Hi Chris,

Comments on the Transport Statement:

**Figure 7.1 – Side roads within 200m walking distance from the edge of the development site**

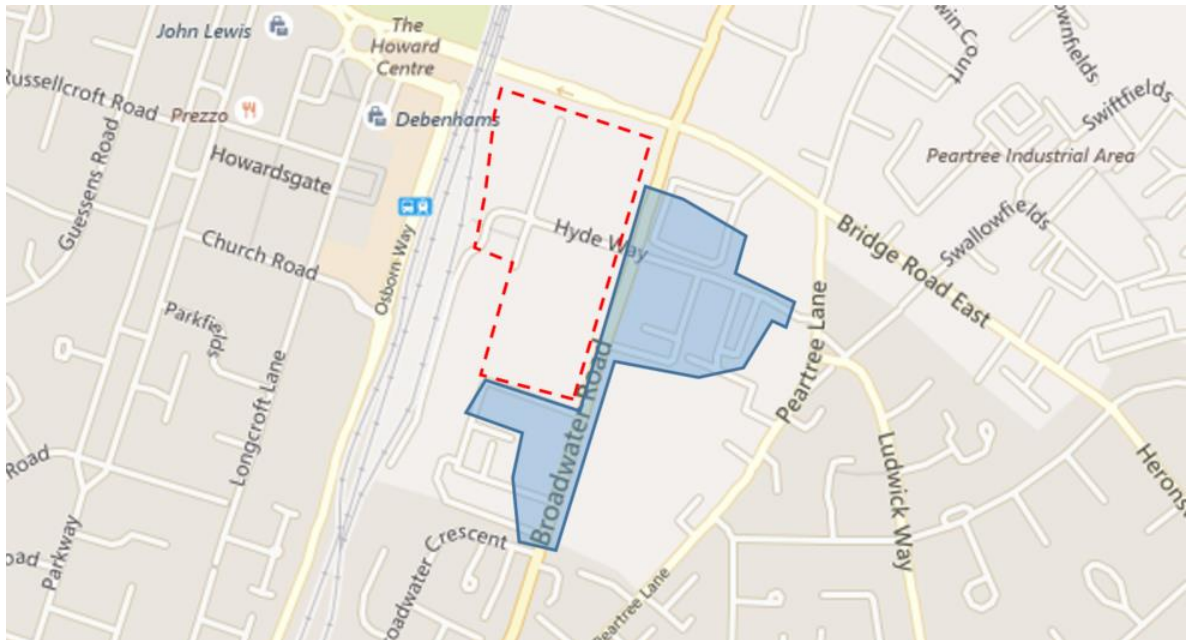
In section 7.5 it states that the surrounding roads 'are covered by comprehensive waiting restrictions'. I challenge this statement as many roads have no restrictions at all and some only have junction protection. Most of the waiting restrictions which are in place are day time only and I feel the displacement of vehicle from this development in to residential roads surrounding the development will take place on evening and weekends which this would not address.

In the same section it also states if any displace does occur then 'it would be a simple matter for the development to fund any traffic regulation orders'. Dependent on the displacement and the times which TRO would need to cover this also may impact enforcement as we currently stop at 6.30pm and only have skeleton staff on two Sundays per month.

Who would be paying for additional resource to provide enforcement?

Who would be expected to create the TROs which may need to be produced and consulted on?

**Figure 11.1 – Draft residents parking space request protocol**

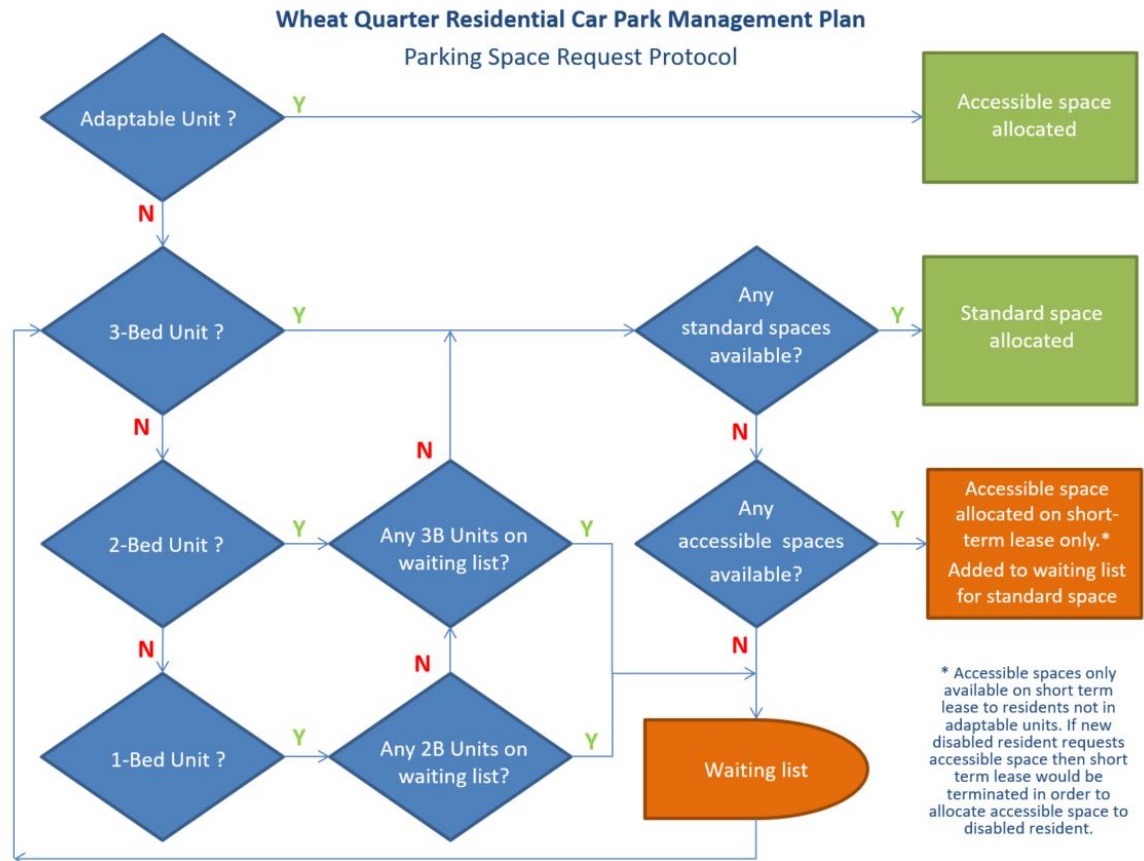
In Section 7.10, it states the parking spaces will be provided on request for a fee. I would like to understand what this fee will look like, as this is likely to put people off and they will look for alternative options off site so they do not have to pay the parking fee.

I see the parking provision will be access only for the undercroft parking facilities, but how will the surface parking spaces be managed?
